Our Ref: SSD-10340-PA-2

**Fort Street Public School (SSD 10340)
Archaeology Research Design and Excavation Methodology (Condition B32)**

As nominee of the Planning Secretary, I am satisfied that the Archaeology Research Design and Excavation Methodology, Issue 5 dated 3 February 2021, has been prepared in accordance with condition B32 of the conditions of consent for the Fort Street Public School SSD 10340.

Figure 7-1 Plan of archaeological actions associated with each zone of potential-c.f. Figure 4-3 and refer to Section 9.2. (Source: Curio 2020)

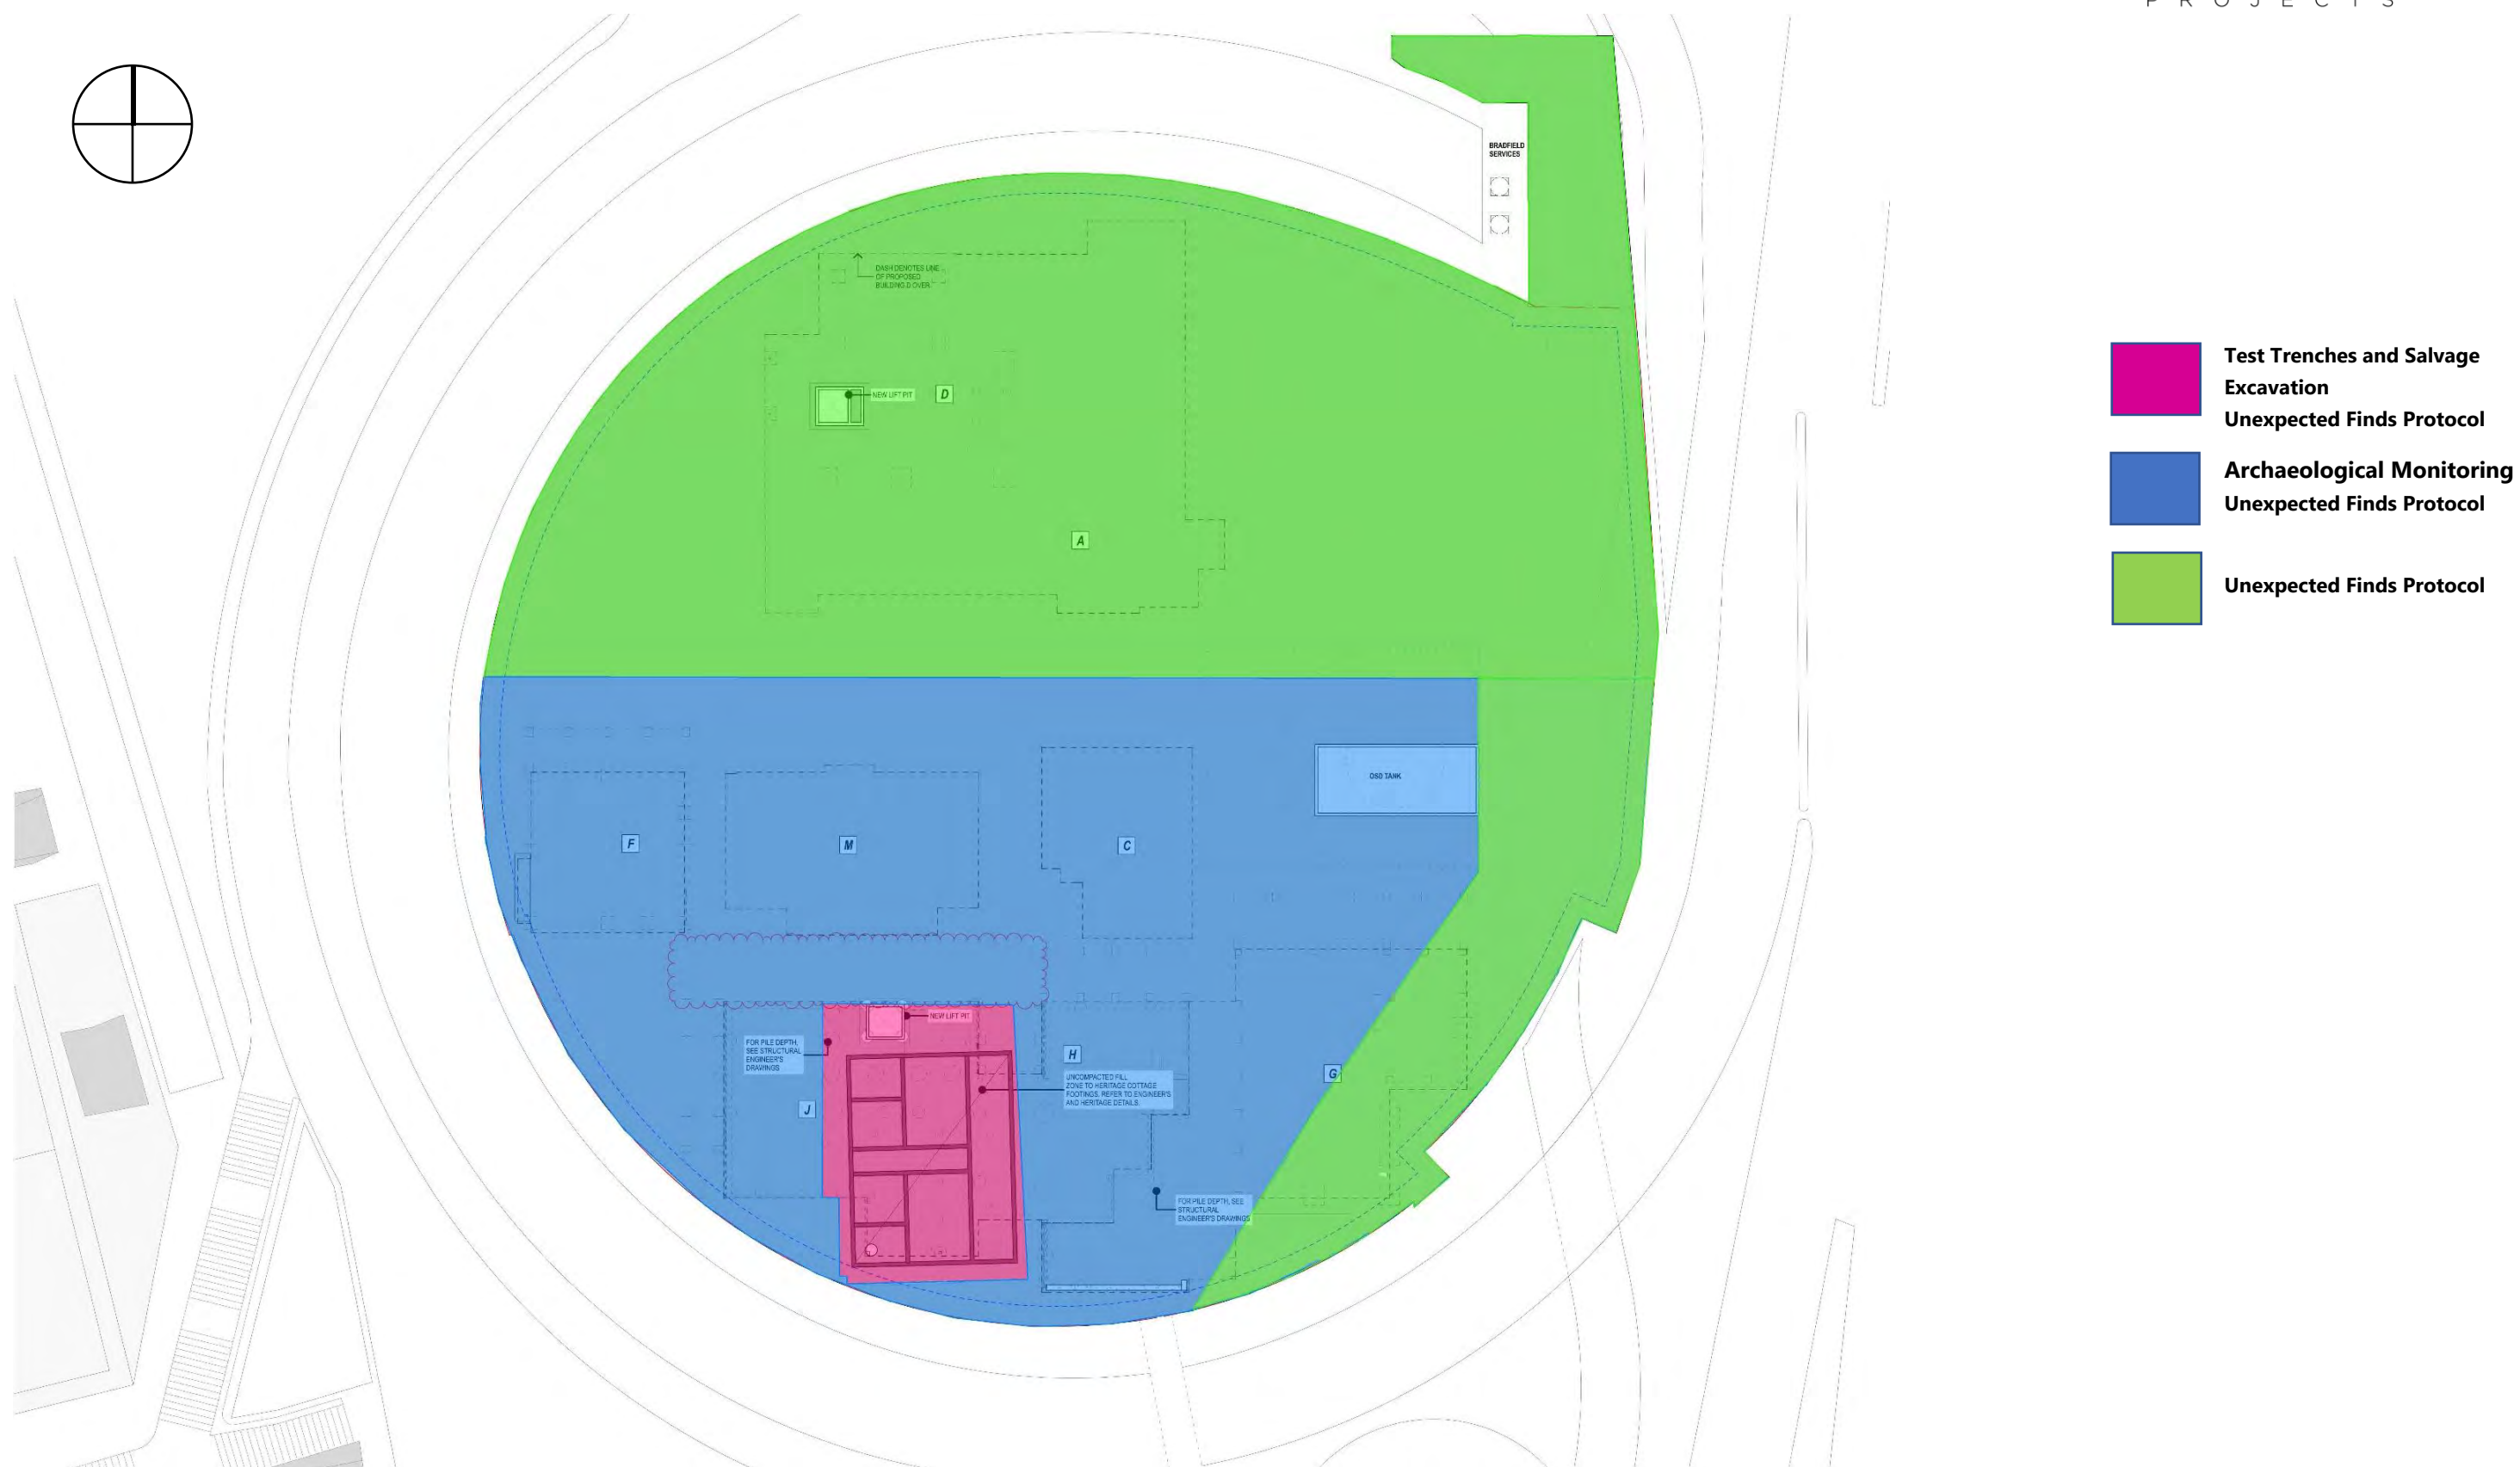
The Applicant is reminded to update Figure 7.1 with improvements to the map legend and references to the demolition plan, so that the area of moderate and high archaeological potential is managed as per the procedures set out in the plan. Please submit a revised plan to the Department for information prior to publication on the project website.
